PROPOSALS FOR
WOODFOLD VILLA
nr. BLACKBURN, LANCASHIRE
SPECIALIST DESIGN REVIEW COMMENT
PARA 80e

Jeremy Musson, MPhil, FSA

August 2022

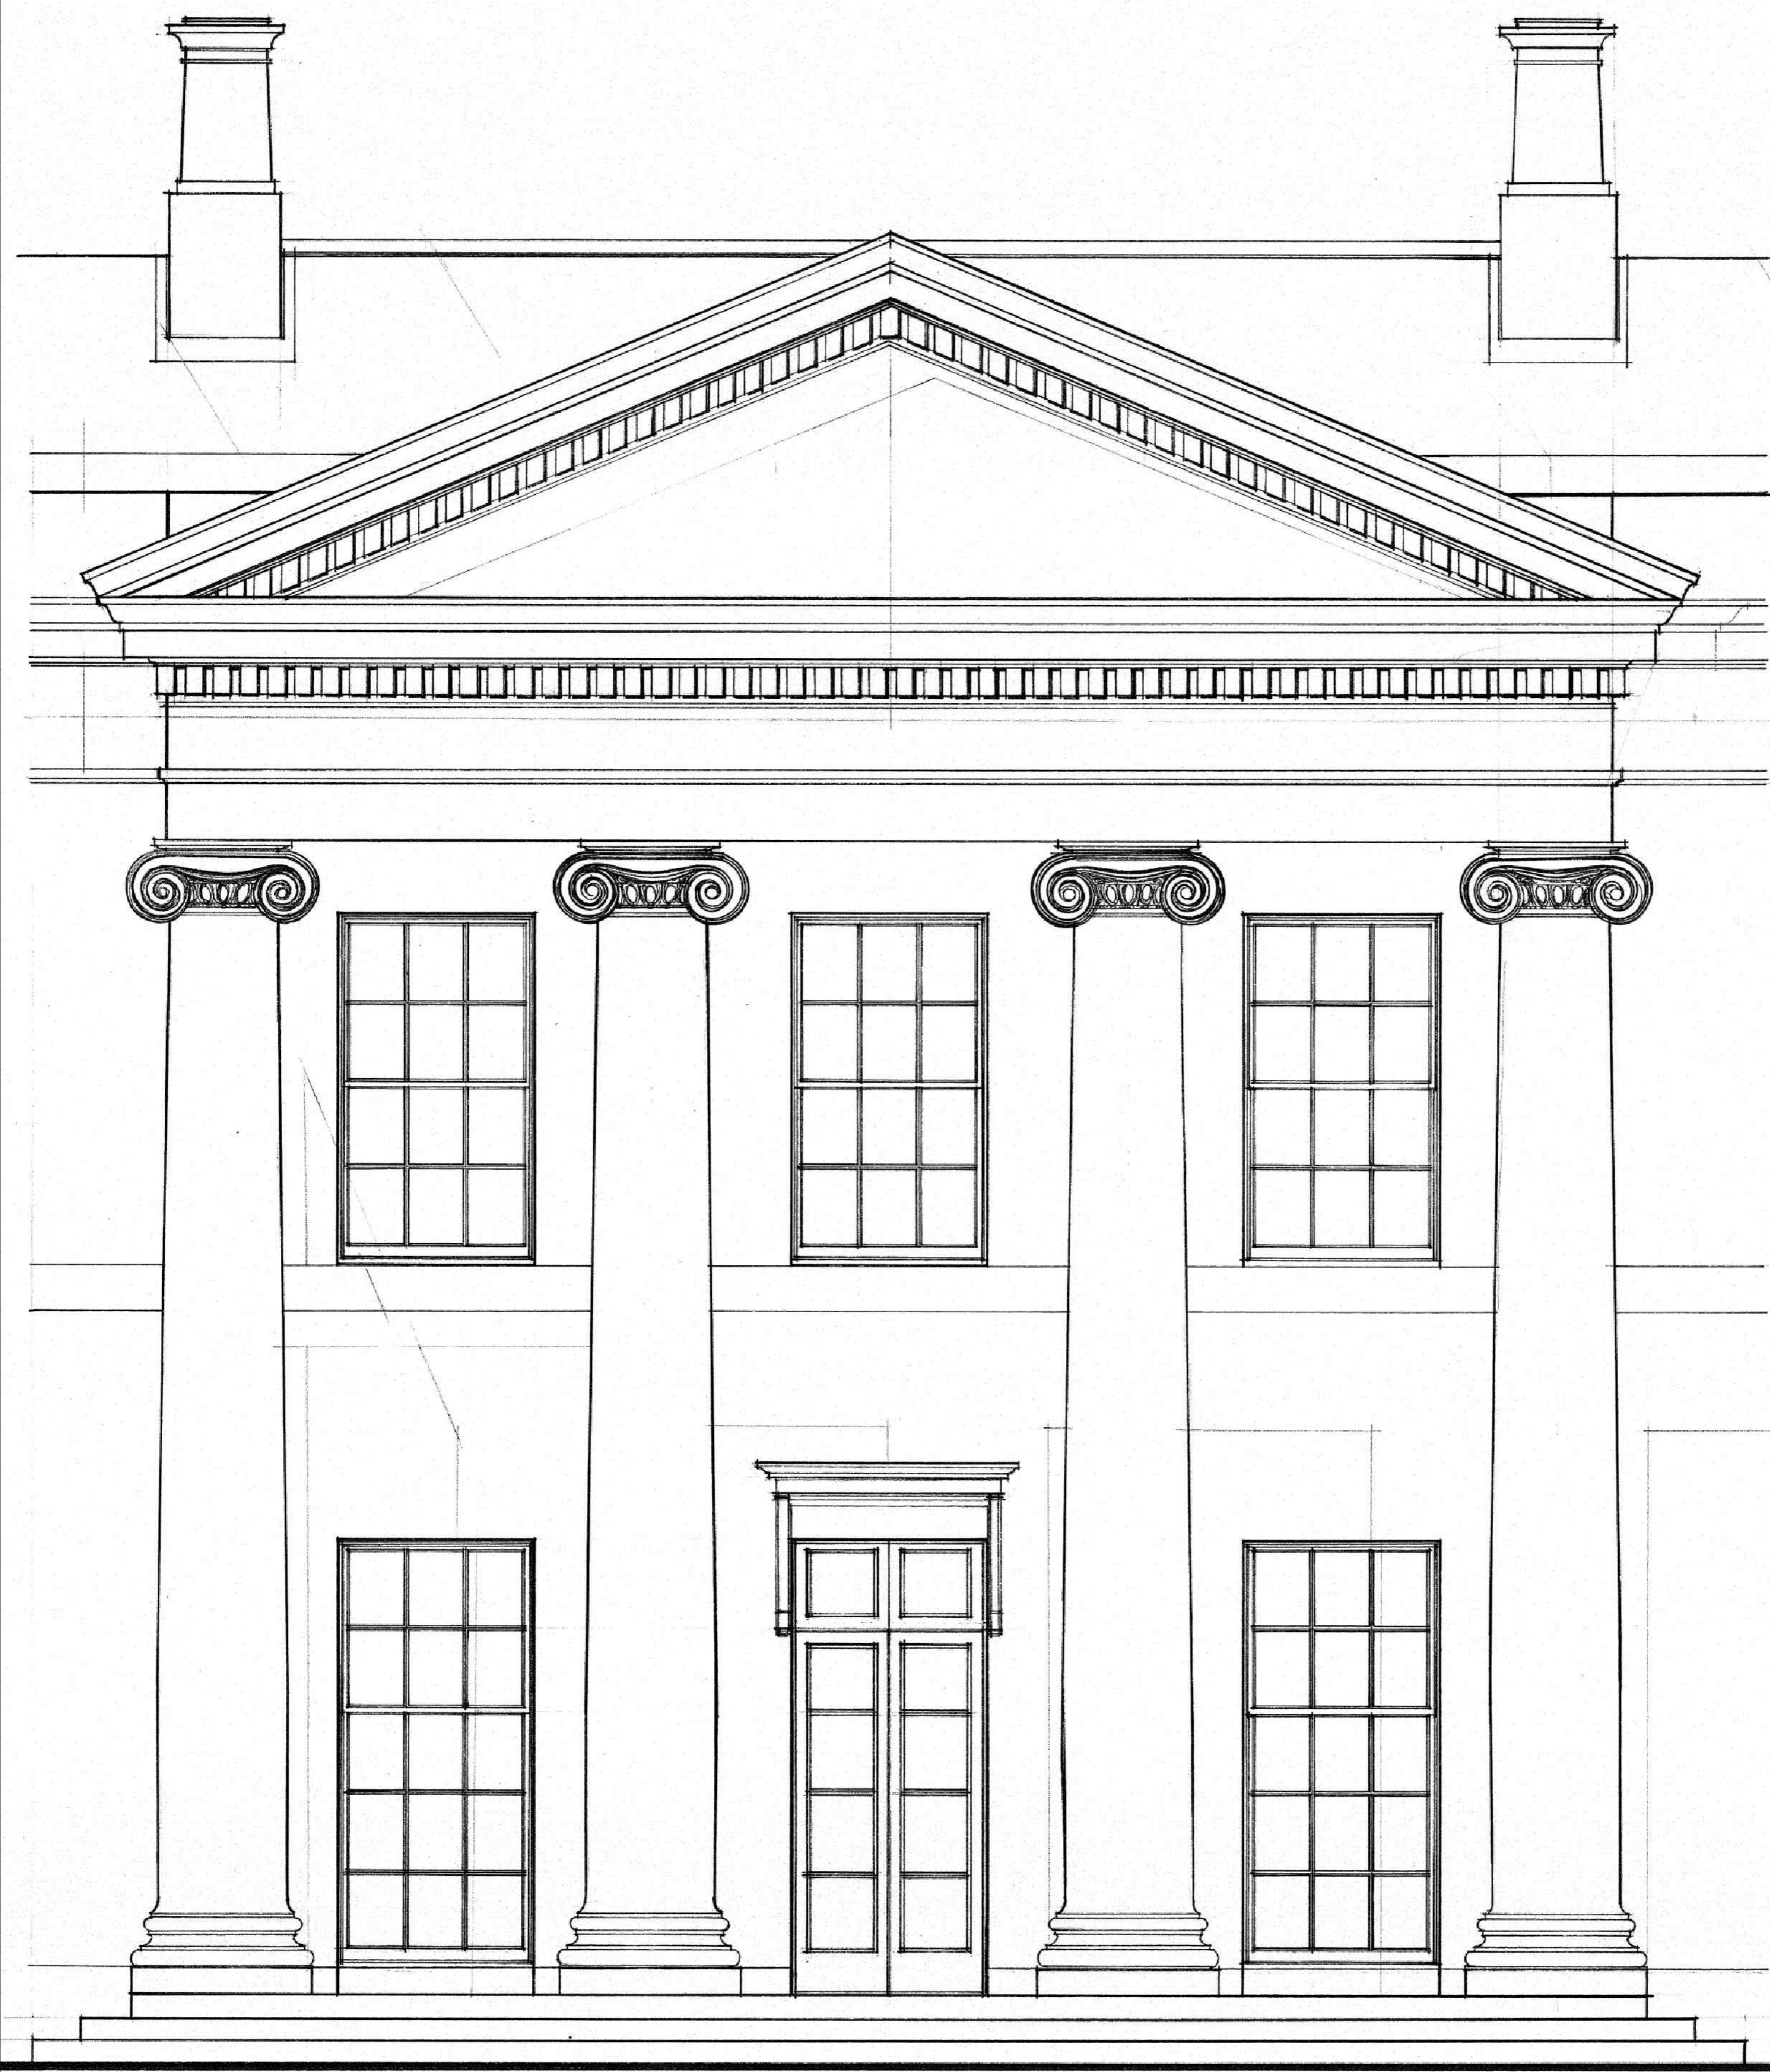
The principal front, of five bays with an Ionic portico, is a subtle and harmonious composition, deriving its quality from careful proportions, and a studied neo-classical plainness. It faces north towards the long horizon views. The west elevation is in effect a five-bay core, framed by single bay pavilion style ends with double-height bows with three tall sash windows to each bow.

This elevation is elegantly modulated with the glazed in loggia - echoing the open loggia of the G.S.Repton-designed Sheringham Hall - allowing enjoyment of distant views. The roof of the loggia, behind a stone parapet with decorative open ironwork panels, forms a balcony for rooms on the first floor.
